From: Tim Rainbird [REDACTED]
Sent: 07 September 2017 12:04
To: Simon Davis; Tom Woolner
Cc: Paul Cann
Subject: RE: BE/71/17/PL - Wickes, Bognor Drainage Scheme

Comments;

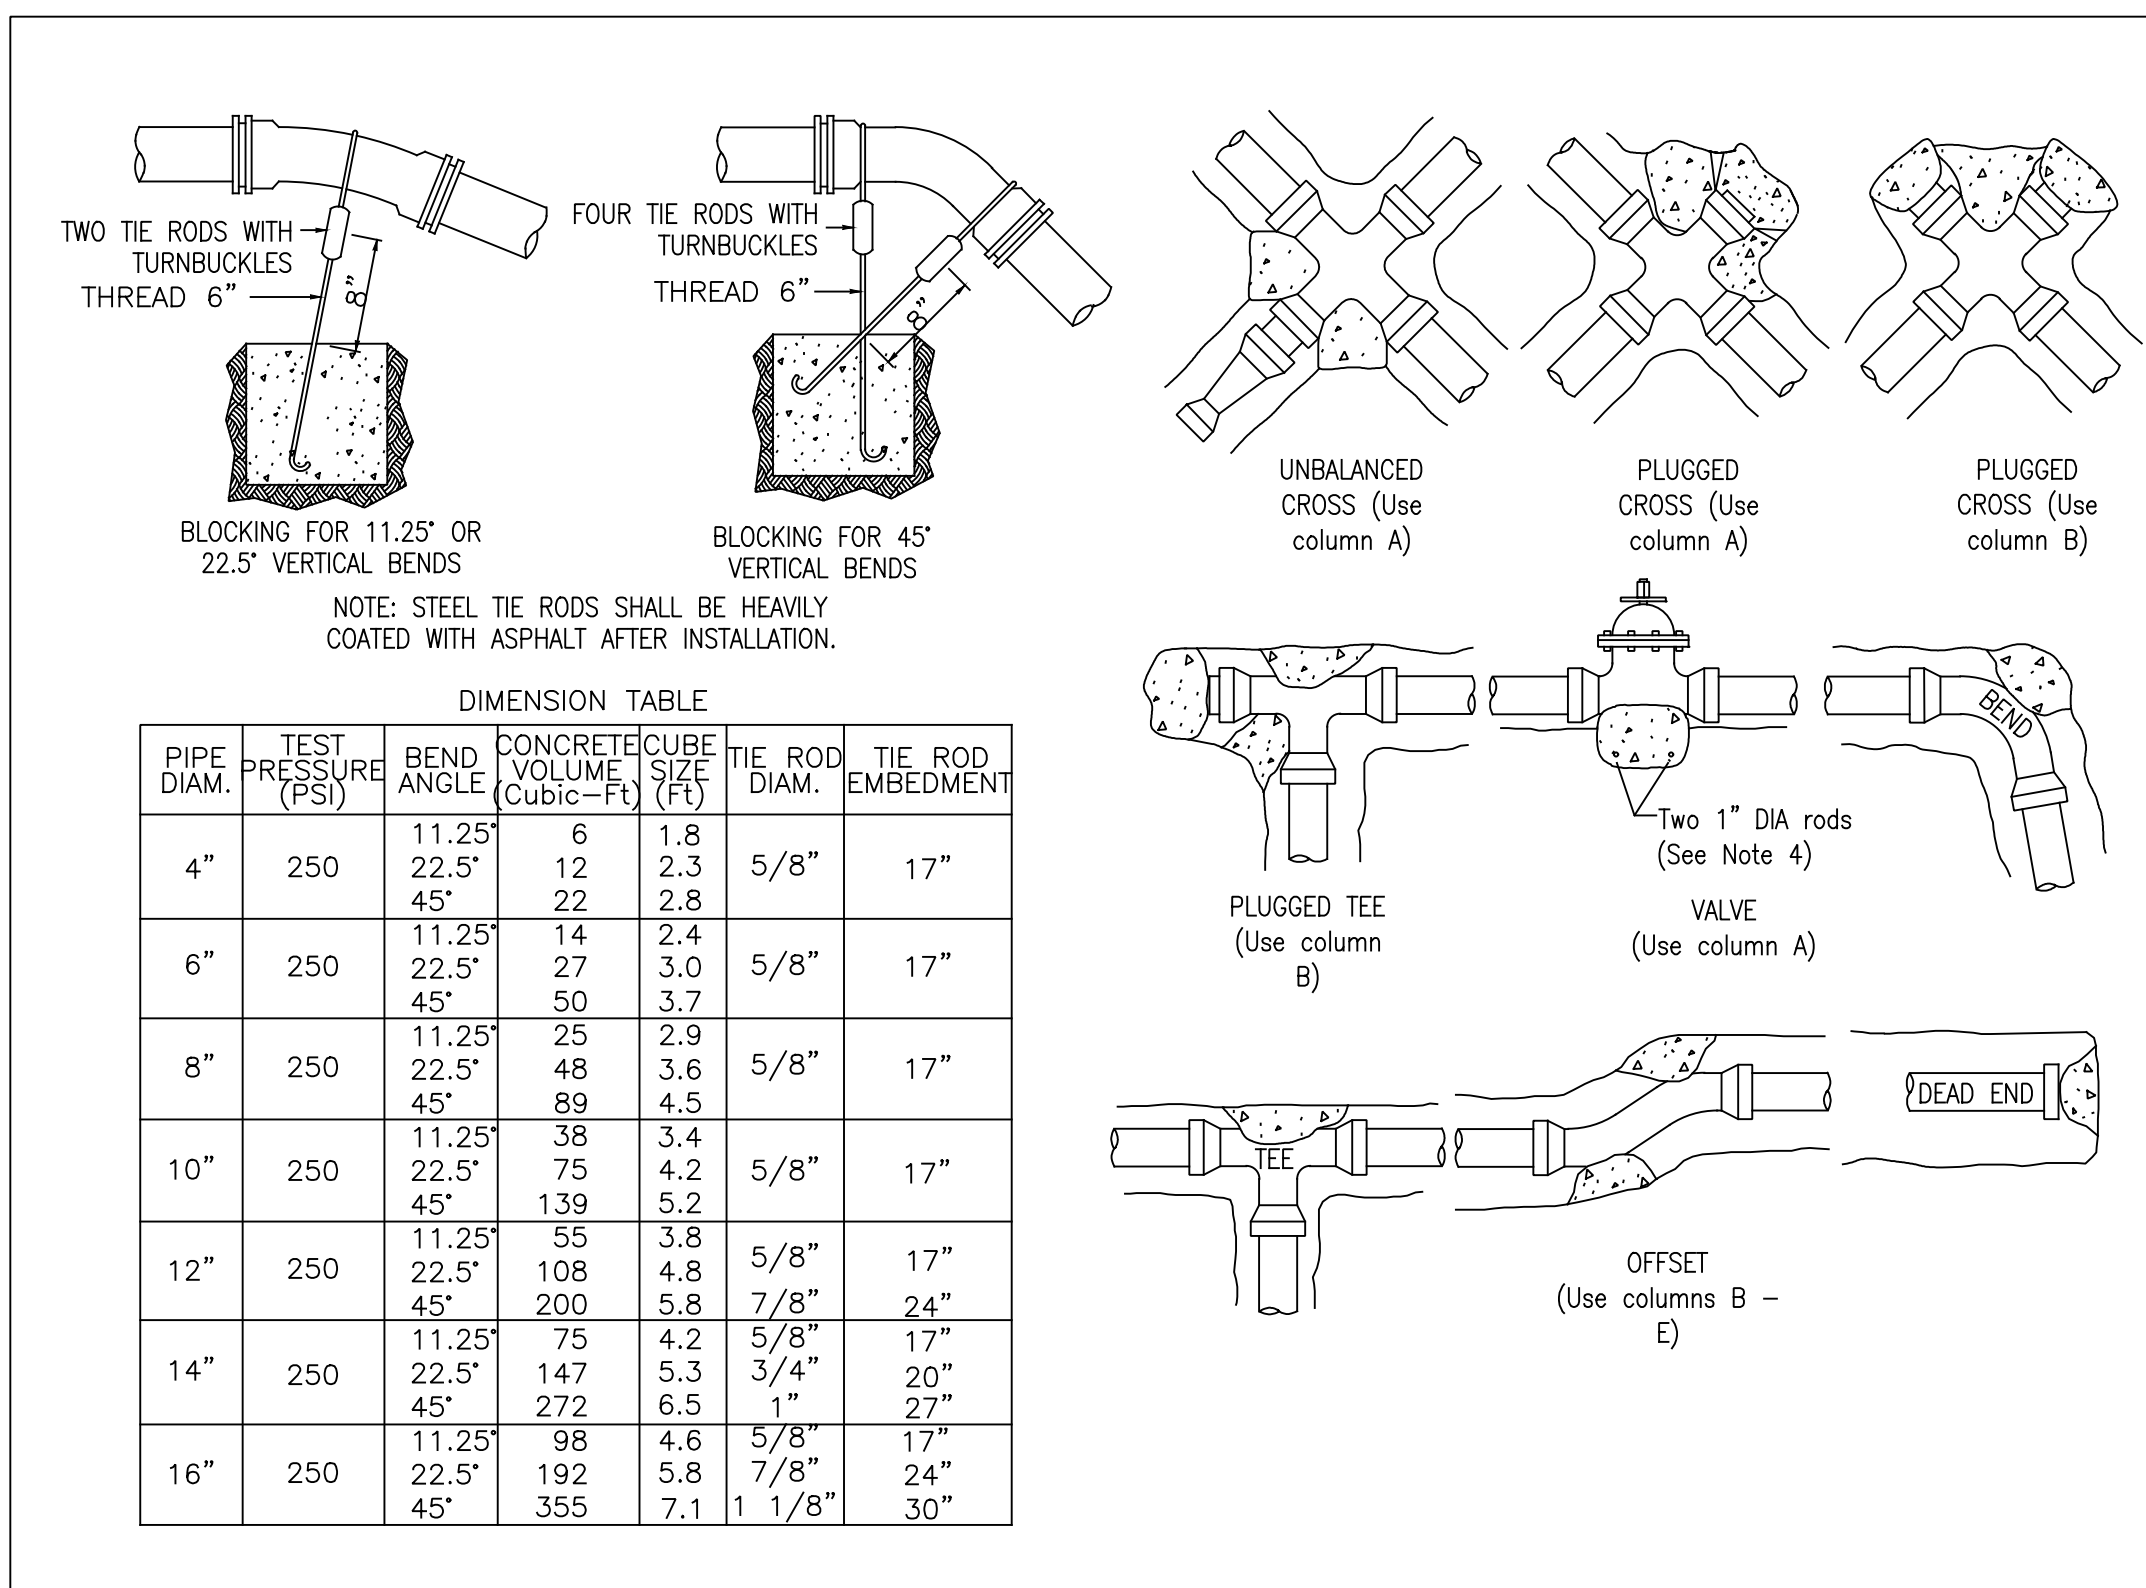
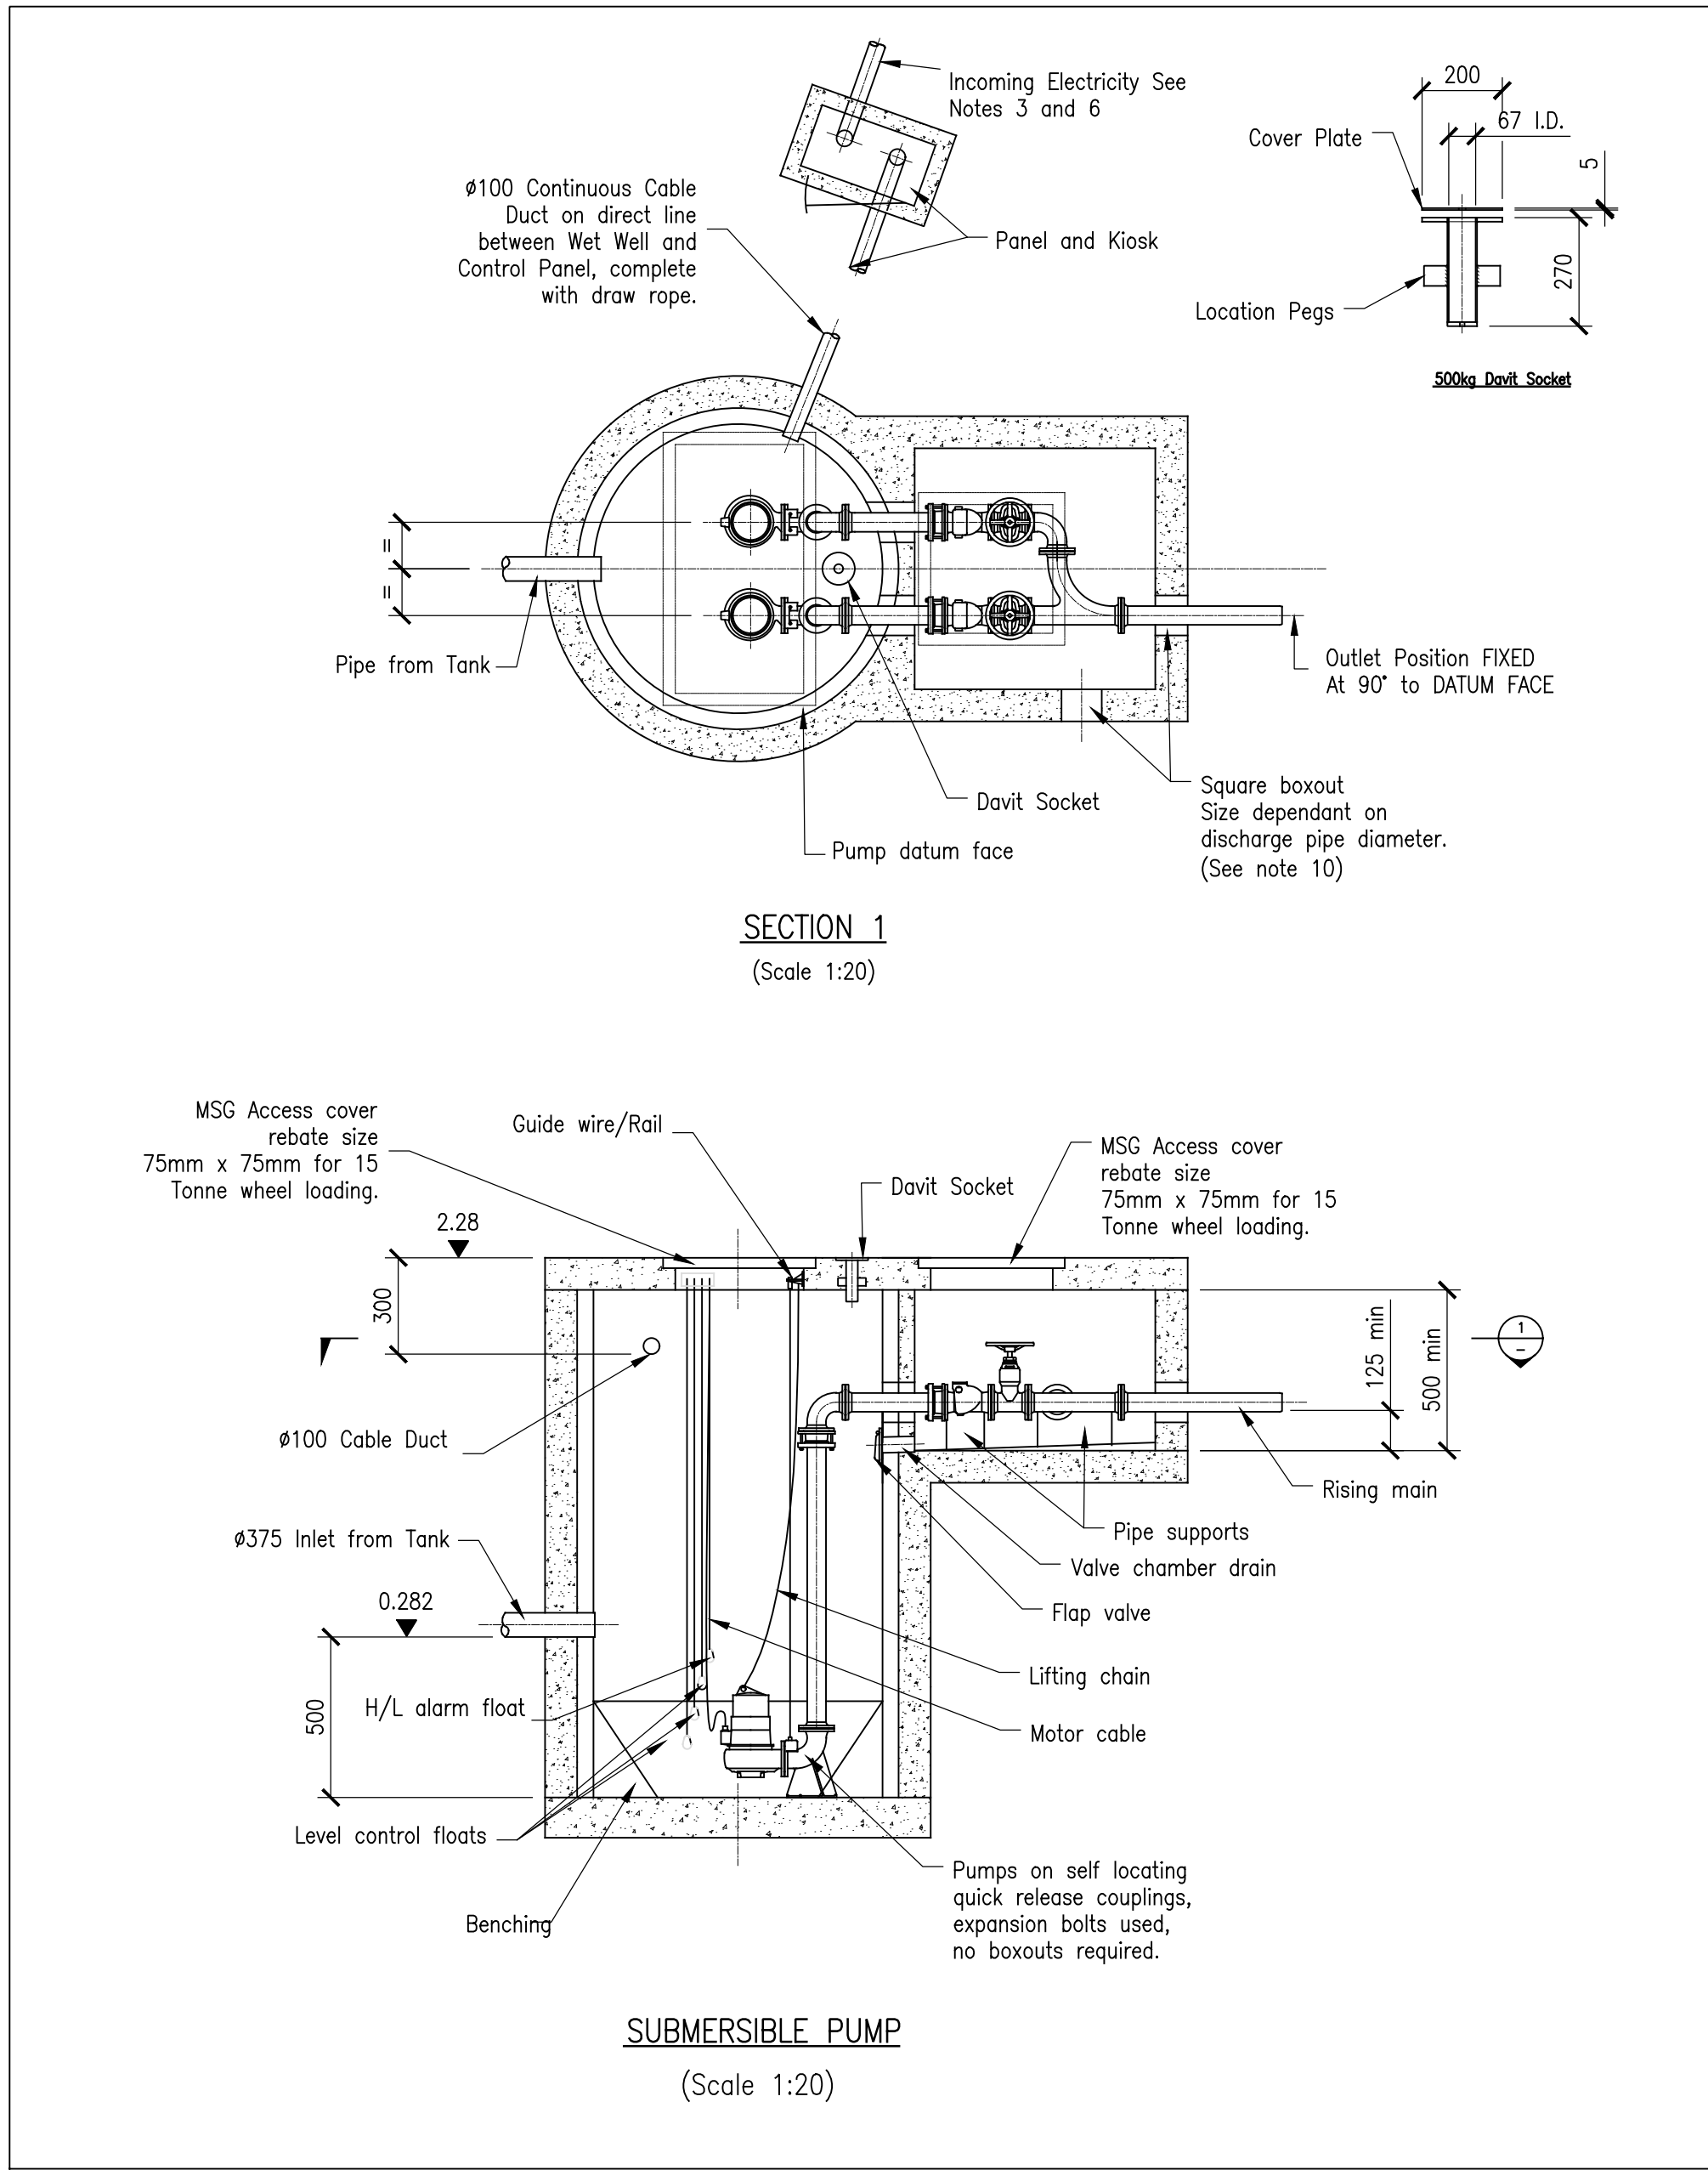
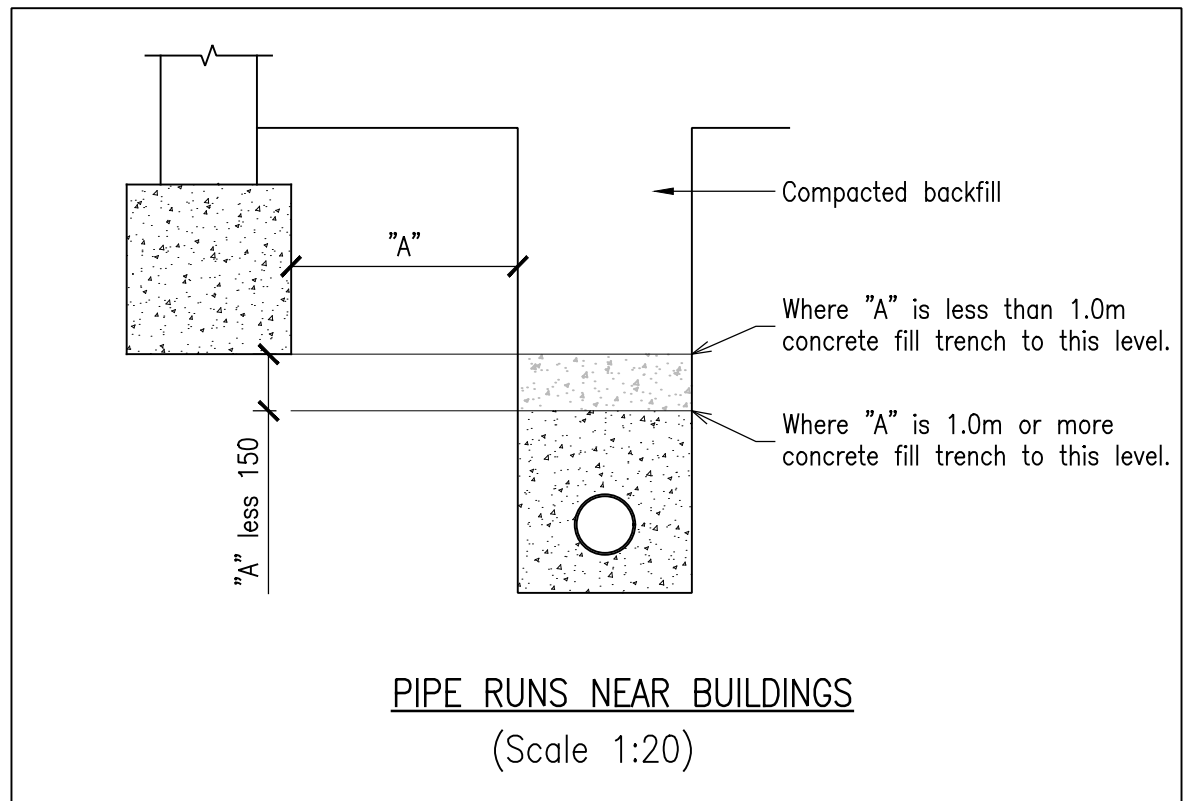
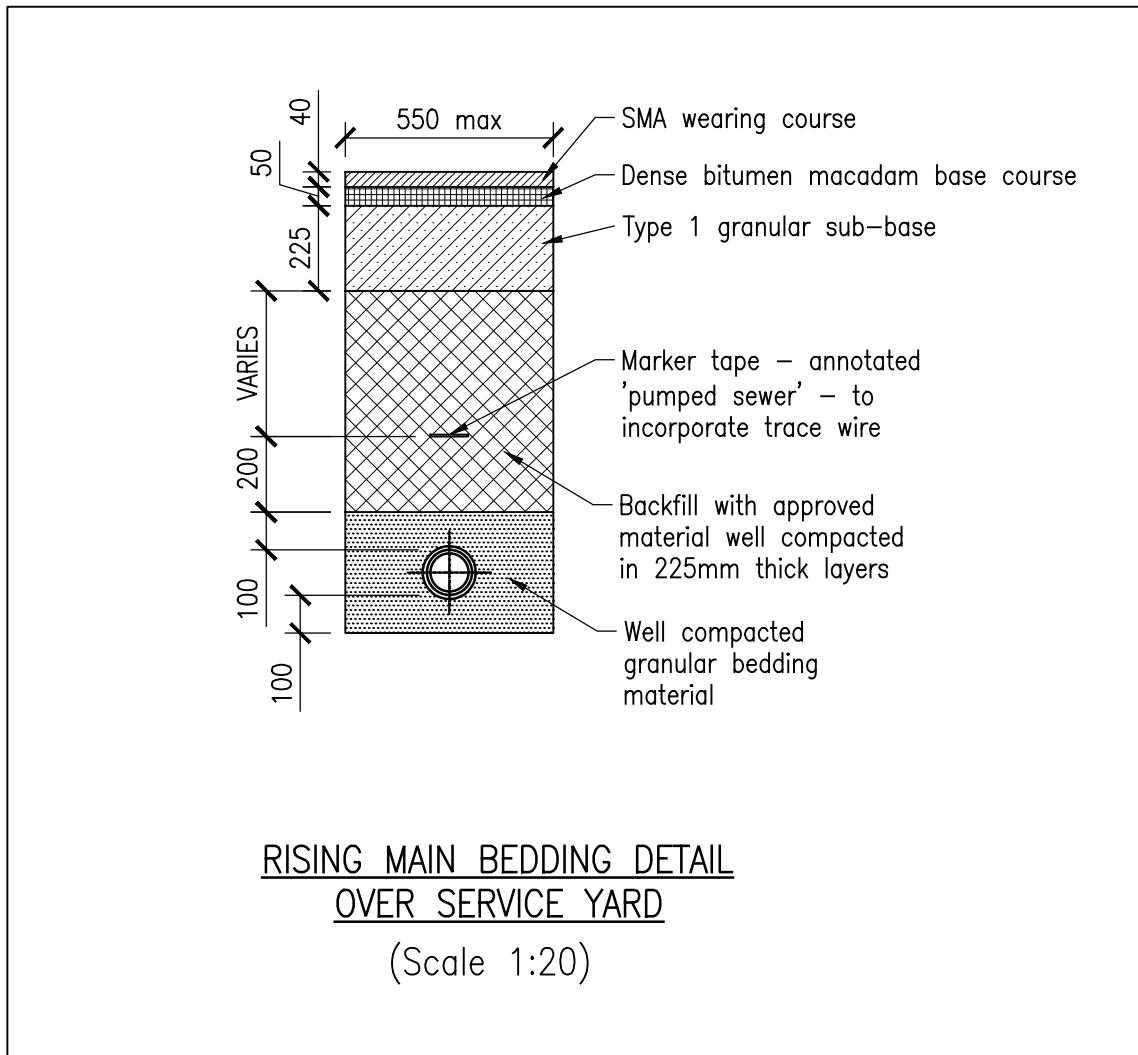
1. Full construction details of the pumping station and rising main. This will also need to include pipe bedding details, thrust block details and discharge chamber details.
2. Malfunction alarm details for the pumping station.
3. Pump manufacturers design/spec.
4. A maintenance plan for the future operation/maintenance of the pumping station.

It is important that the pipework configuration is considered carefully within the discharge chamber to ensure the smooth transition of flows. This will need to be detailed.

1. Full construction details of the pumping station and rising main. This will also need to include pipe bedding details, thrust block details and discharge chamber details.

Typical details are on the attached drawing 15-112/500
